WEST SUSSEX COUNTY COUNCIL CONSULTATION

TO:	Arun District Council FAO:Andrew Wood
FROM:	WSCC - Highways Authority
DATE:	17 September 2019
LOCATION:	Unit 1 Bullocks Yard Ford Lane Ford BN18 0EF
SUBJECT:	F/12/19/PL Change of use from boat & marine leisure yachts manufacturer to vehicle MOT testing station. This application may affect the setting of a listed building. More information.
DATE OF SITE VISIT:	n/a
RECOMMENDATION:	Modification
S106 CONTRIBUTION TOTAL:	n/a

Unit 1 - Location Plan

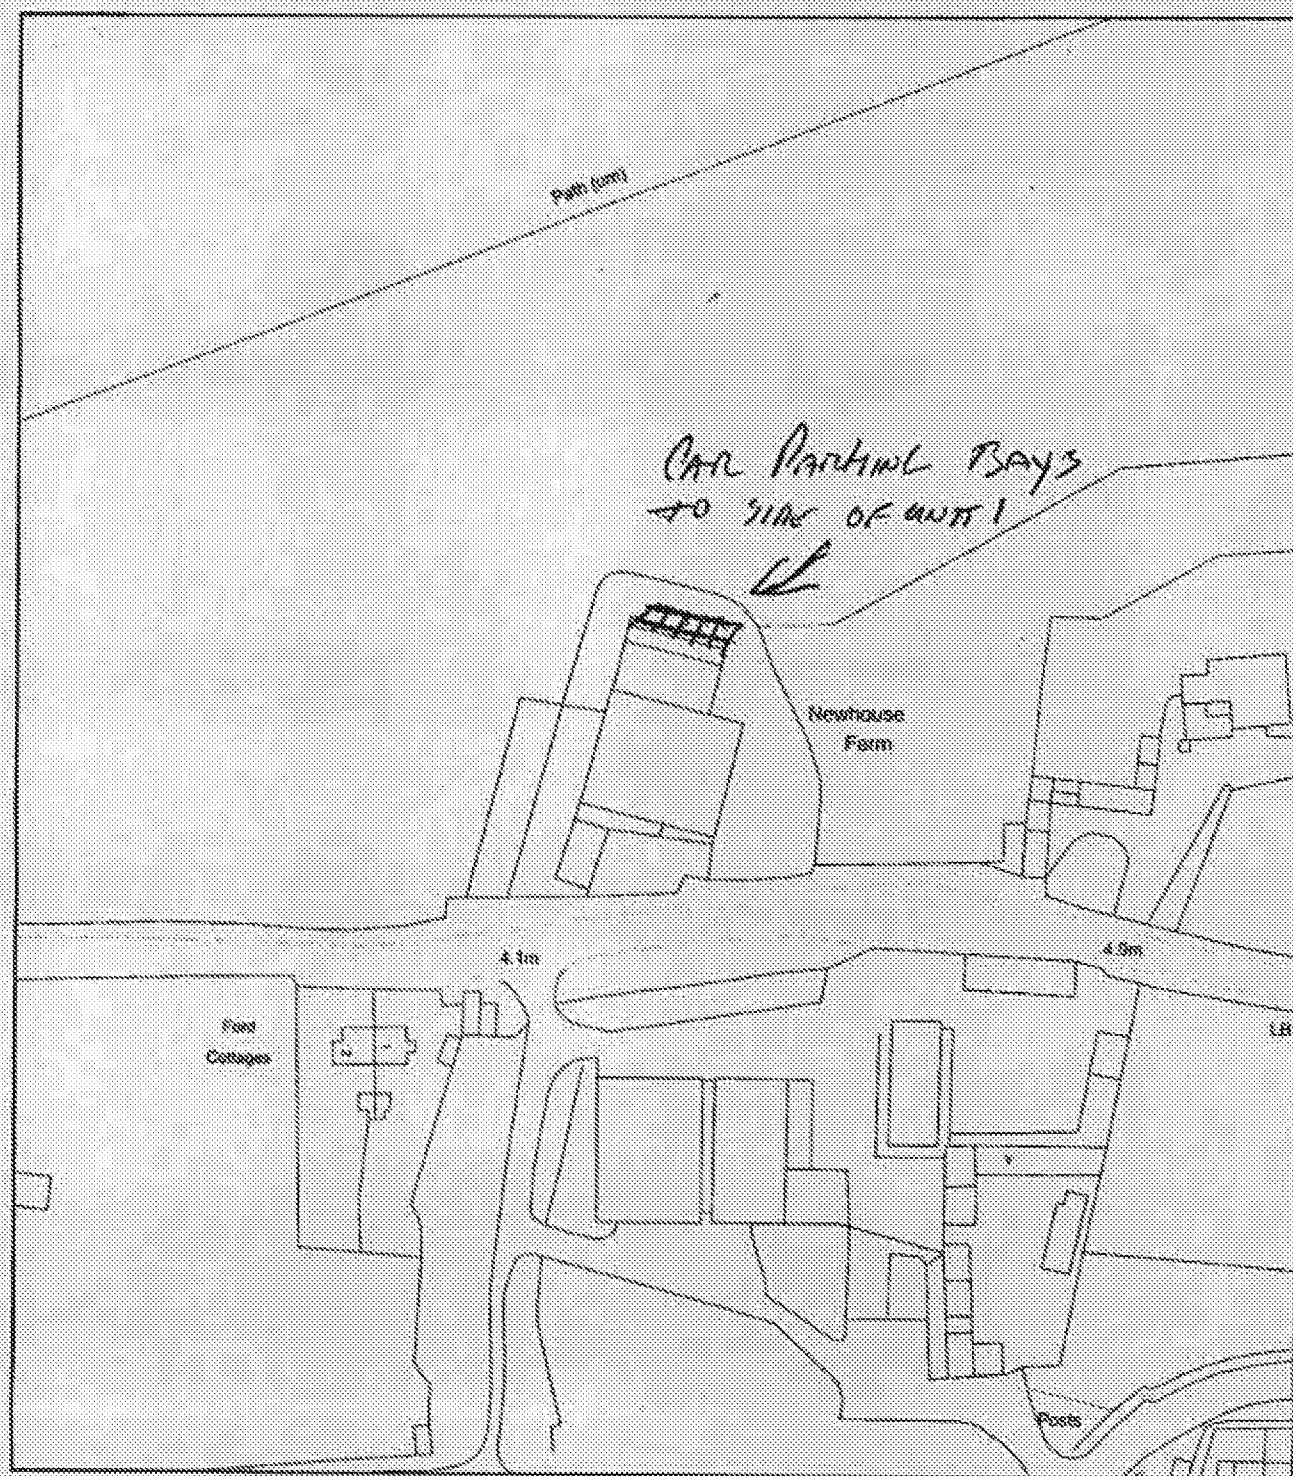
The applicant has failed to provide a clear scaled parking area on their plan. The applicant should clarify the number of spaces provided, with some justification taking into account the operational needs of the business. It is anticipated that an appropriate provision can be provided within the site. While this is likely not an overriding highway safety concern the LHA would request that all parking bays are demonstrated on a scaled plan. The applicant should be minded that a single bay parking space should measure a minimum of 2.4 x 4.8 metres or 3.0 x 6.0 metres for a single parallel parking space as per WSCC and manual for Streets (MfS) Guidance.

Whilst there are no overriding highway safety or capacity concerns with the proposal before me now, the applicant would be advised to modify the proposed parking provision.

Alternative left-hand visibility splay if vehicle approaching from the left are unable to cross the centre line

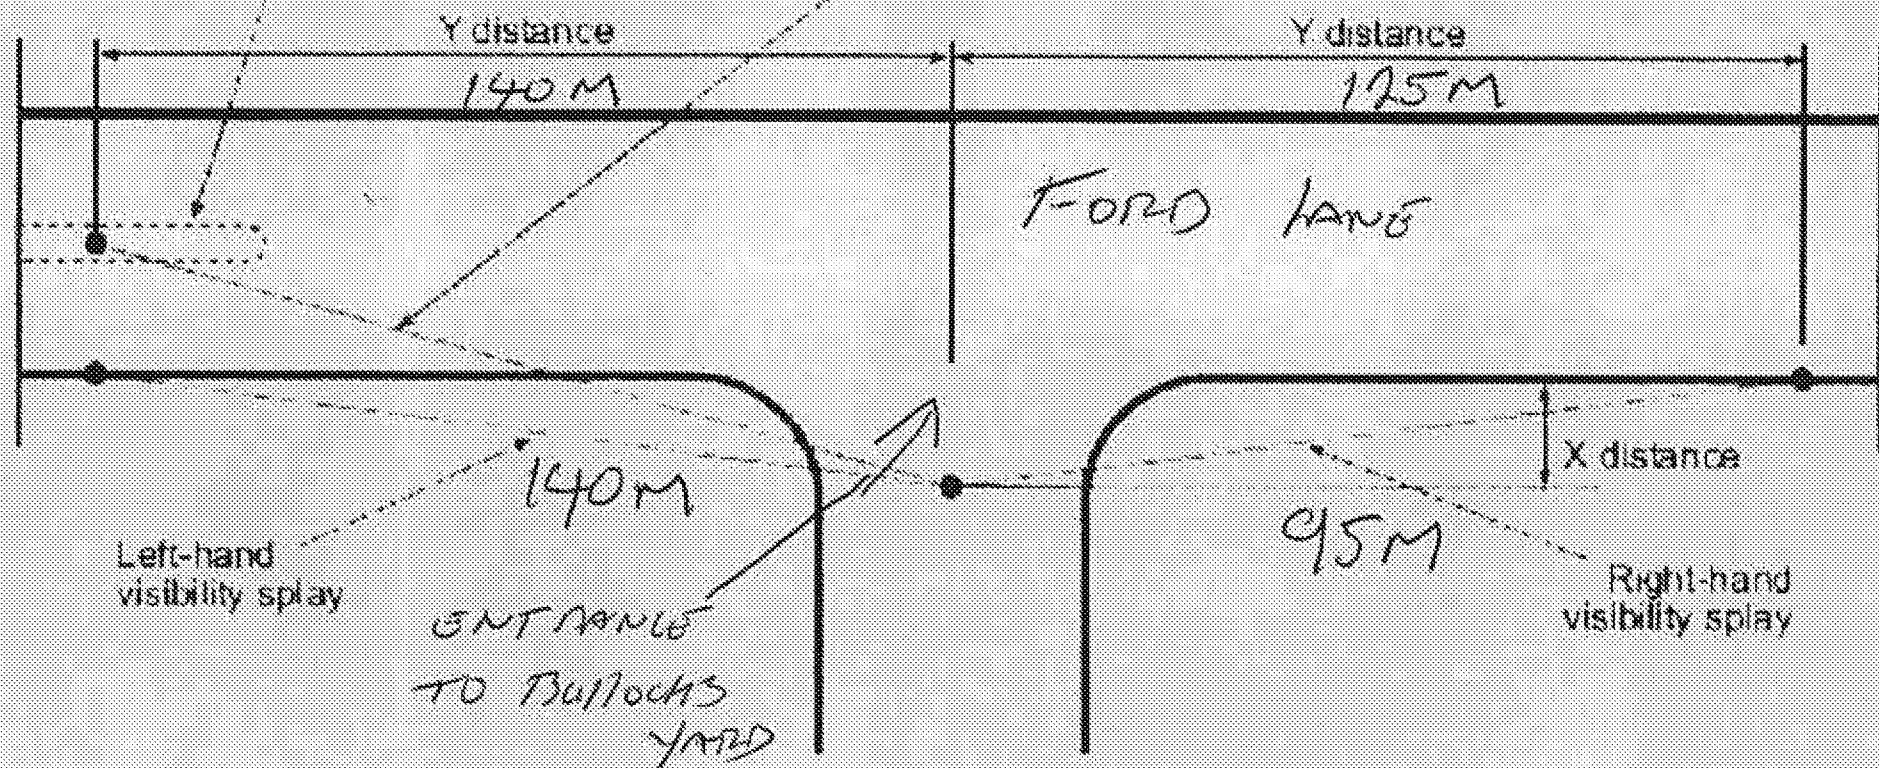
The applicant has demonstrated visibility splays. These however have been demonstrated on a plan that does not represent the road layout present outside the application site. Upon inspection of WSCC local mapping however; the LHA can determine that the proposed visibility of 140 metres to the East and 95 metres to the West can be achieved.
